From: [Holly Erdman](#)
To: [Rachael Stevie \(CD\)](#)
Subject: RE: BL-20-00010 Shopbell Ranch - Notice of Application
Date: Thursday, April 16, 2020 10:58:26 AM
Attachments: [image001.png](#)

From: Rachael Stevie (CD) <rachael.stevie.cd@co.kittitas.wa.us>
Sent: Tuesday, April 14, 2020 6:58 AM
To: Pat Nicholson <pat.nicholson@co.kittitas.wa.us>; Candie Leader <candie.leader@co.kittitas.wa.us>; Holly Erdman <Holly.erdman@co.kittitas.wa.us>; Jesse Cox <jesse.cox@co.kittitas.wa.us>
Cc: Lindsey Ozbolt <lindsey.ozbolt@co.kittitas.wa.us>
Subject: BL-20-00010 Shopbell Ranch - Notice of Application

Please review the following Boundary Line Adjustment application submitted by Pat and Larry Shopbell- BL-20-00010 Shopbell Ranch. Any comments need to be submitted by 5pm on April 29, 2020. Please let me know if there are any questions.

Proposed

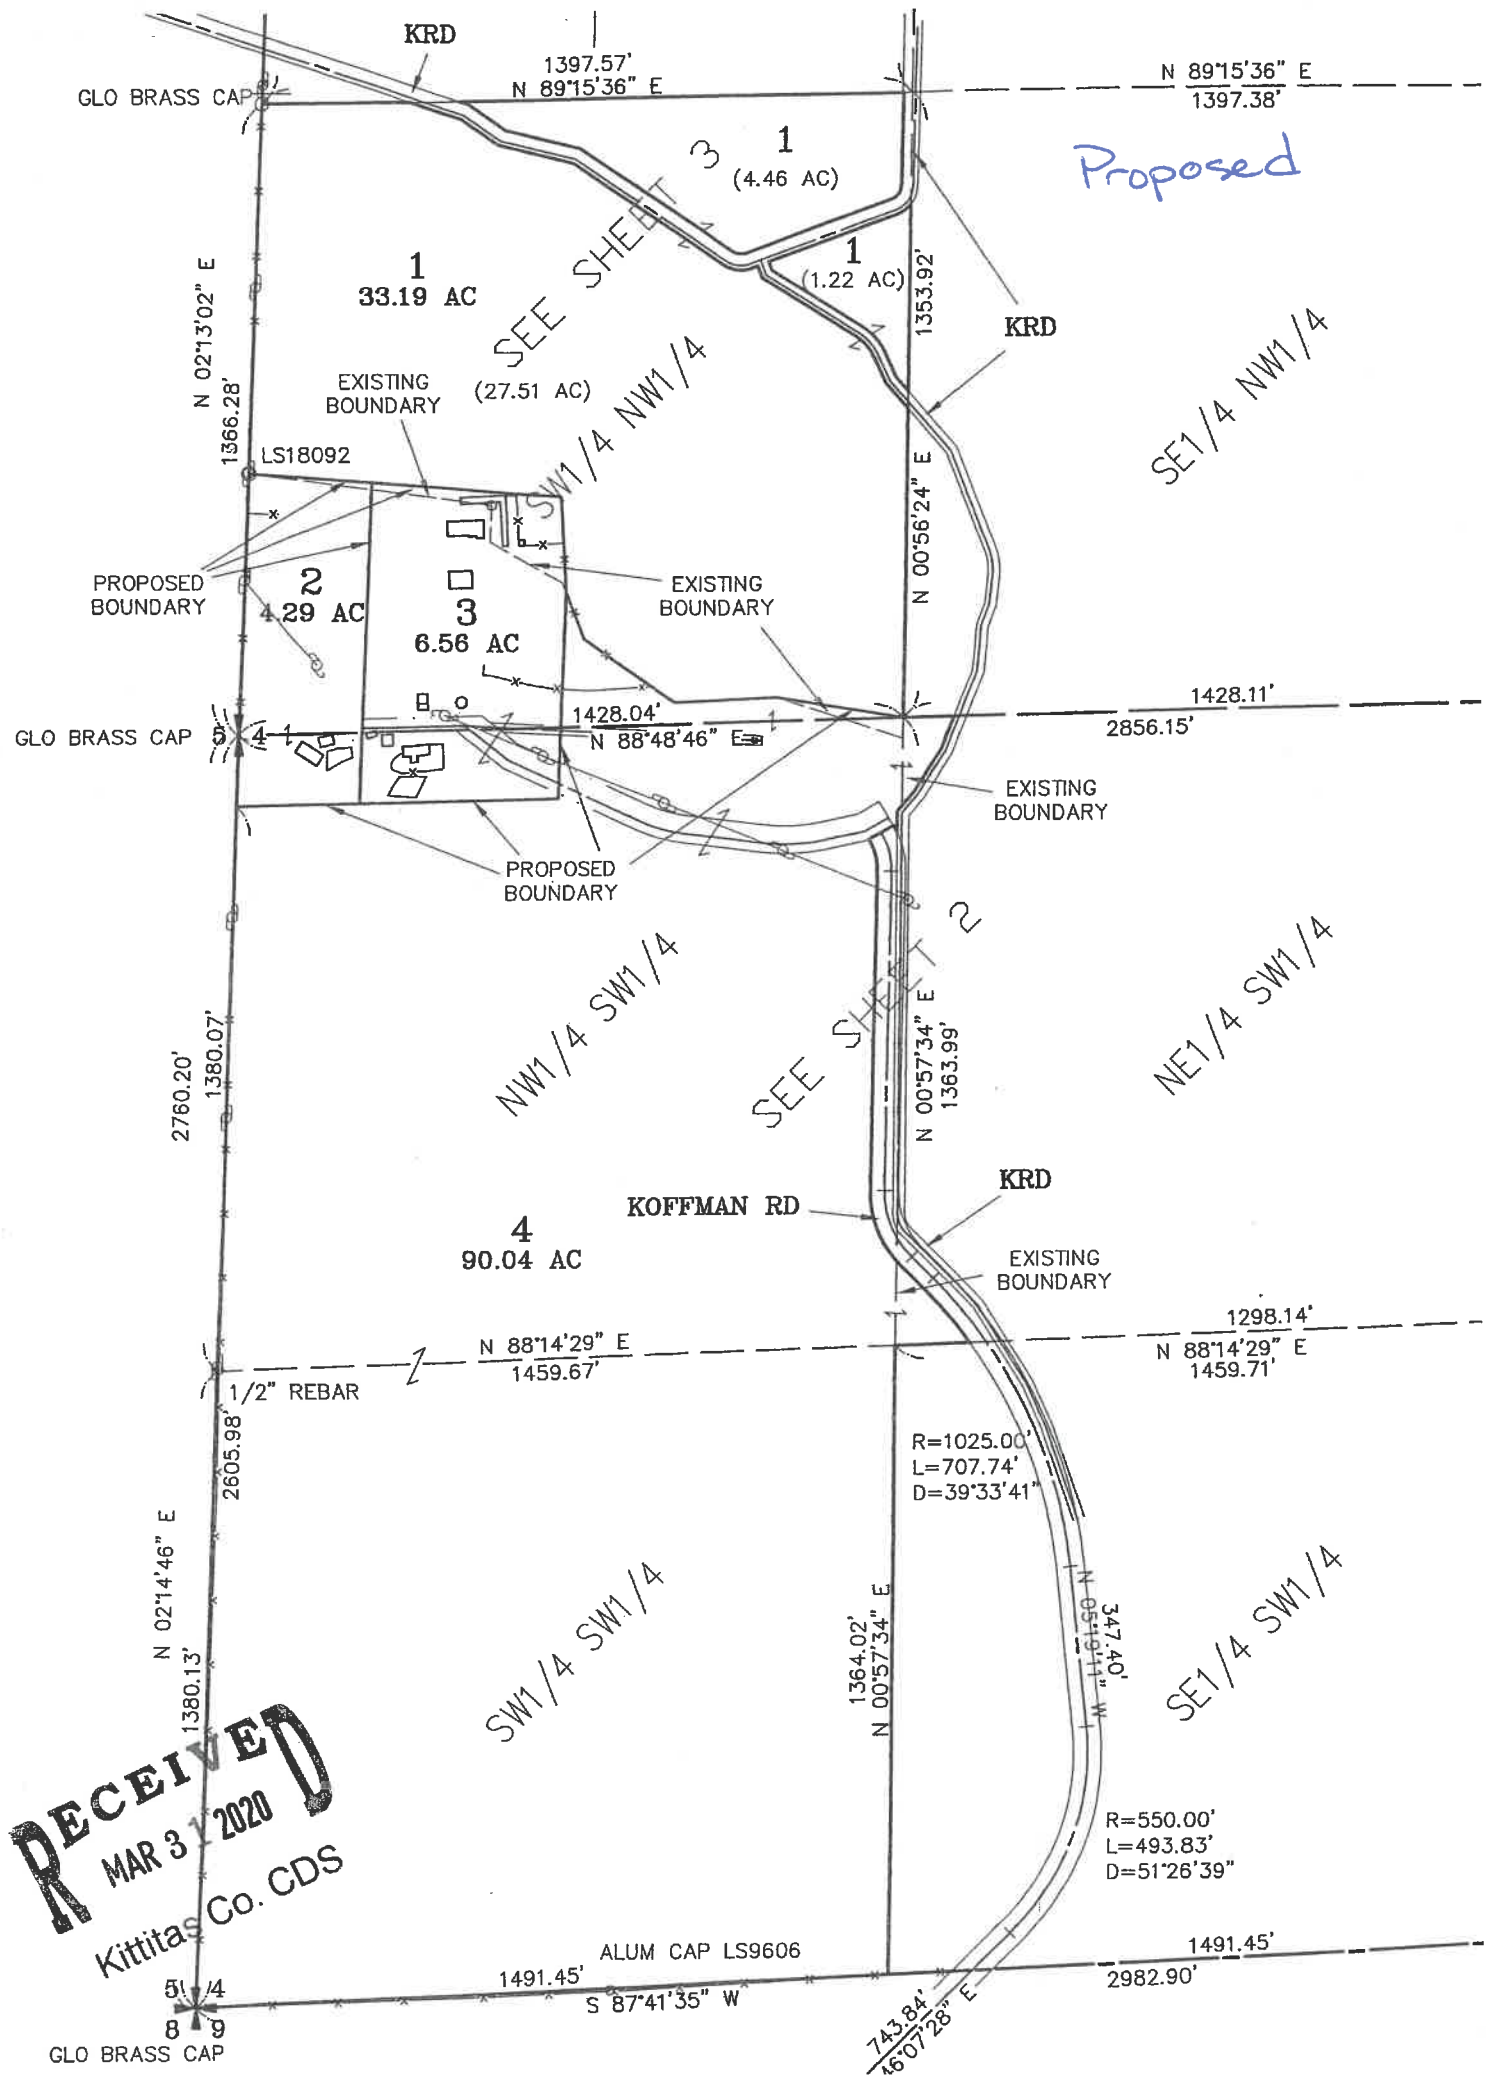
I have reviewed this BL and need the locations of the wells on proposed parcels 2 and 3 to be able to complete my review.
